Re: Taco Bell, 8651 Golf Course NW  
Administrative Amendment Request

Wallace Engineering has reviewed the City comments received May 11, 2020 and has the following response:

SITE PLAN

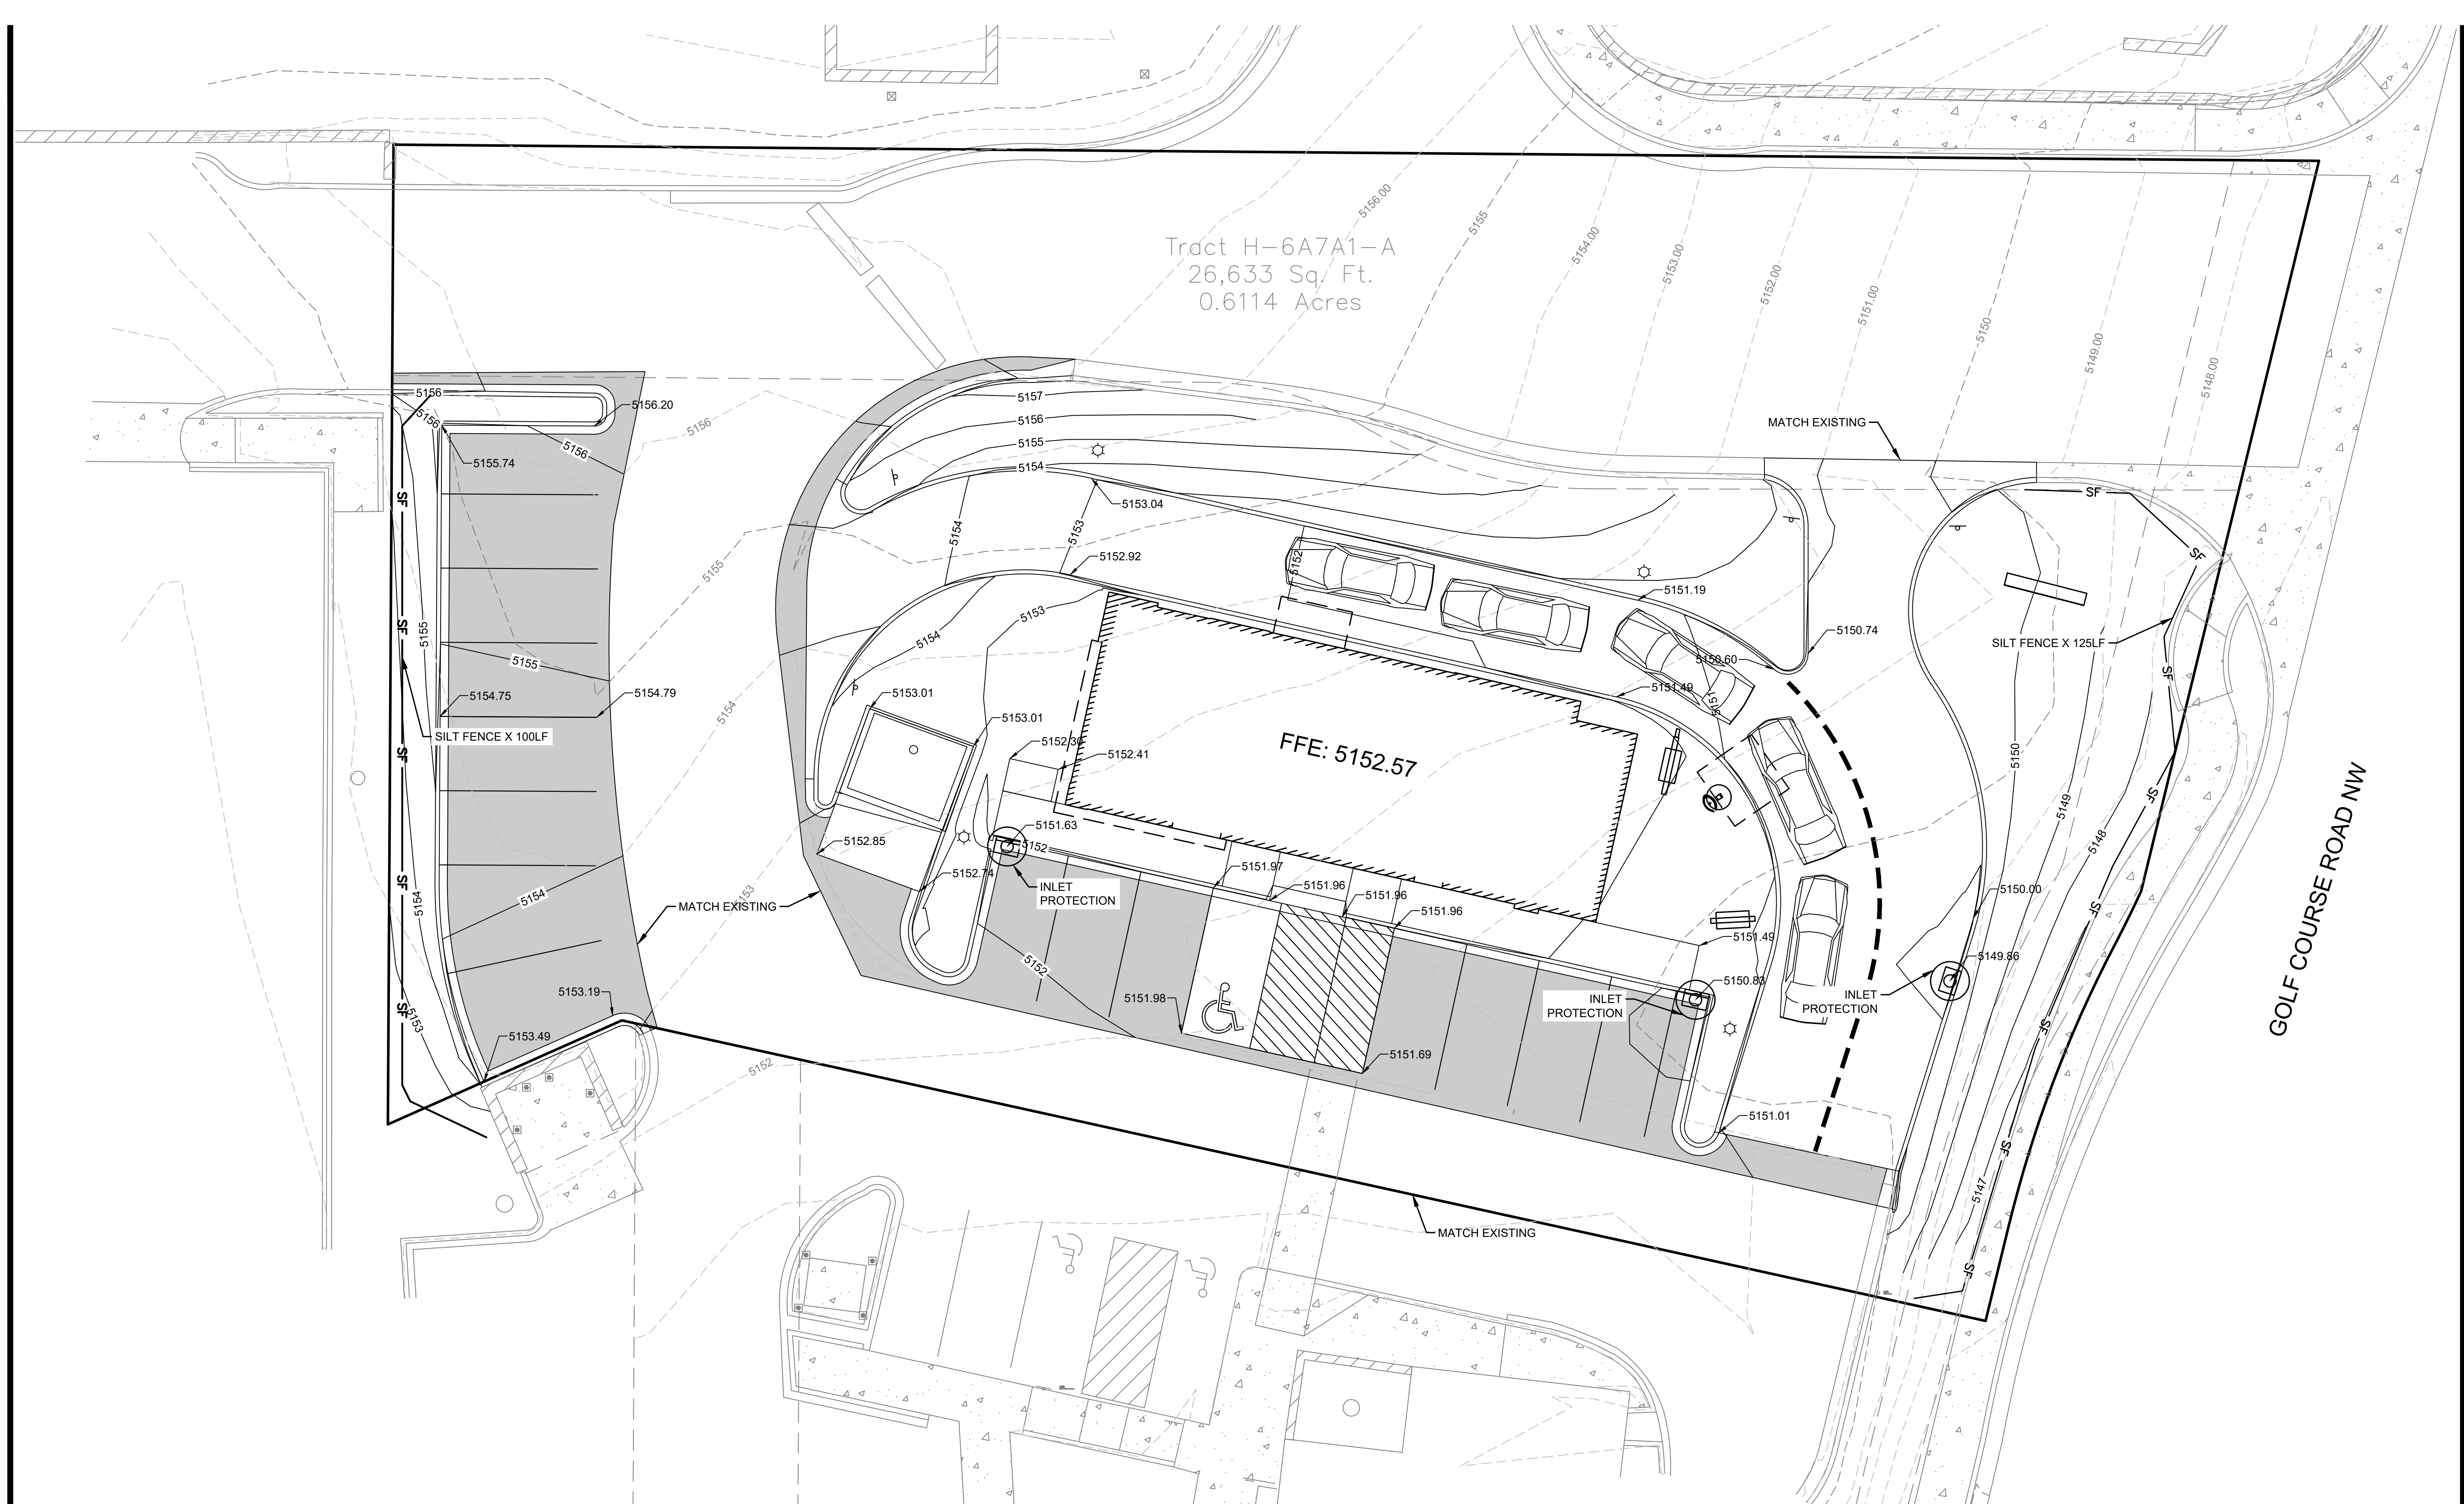
1. Based on the proposed square footage for this Taco Bell, no Traffic Impact Study will be required.
  - *Understood.*
2. A 6-foot ADA pathway is required from the handicapped spaces to the public right-of-way and from the handicapped spaces to the main entrance.

- *As previously discussed, the accessible route from the Taco Bell site runs south to public right-of-way.*
3. Also, place parking bumpers to avoid obstruction of the sidewalk.

- *Added as indicated.*
4. Demonstrate that minimum throat length is met between driving exit from the parking lot and Golf Course Road. Sufficient vehicular queuing must be allowed between Golf Course Road and the driving exit.

10. Please add the clear sight triangle to entrance off of Golf Course for site plan and landscaping plan. Add the following note as well: "Landscaping, fencing and signing will not interfere with clear sight requirements. Therefore, signs, walls, trees, and shrubbery between 3 and 8 feet tall (as measured from the gutter pan) will not be acceptable in the clear sight triangle."

- *Added sight triangle and note on the site and landscaping plans as indicated.*
11. The ADA access aisle shall have the words "**NO PARKING**" in capital letters, each of which shall be at least one foot high and at least two inches wide, placed at the rear of the parking space so as to be close to where an adjacent vehicle's rear tire would be placed. (66-1-4.1.B NMSA 1978)

- *Added as indicated.*
12. The ADA accessible parking sign must have the required language per 66-7-352.4C NMSA 1978 "**Violators Are Subject to a Fine and/or Towing.**" If that language is present it is not visible in the detail.
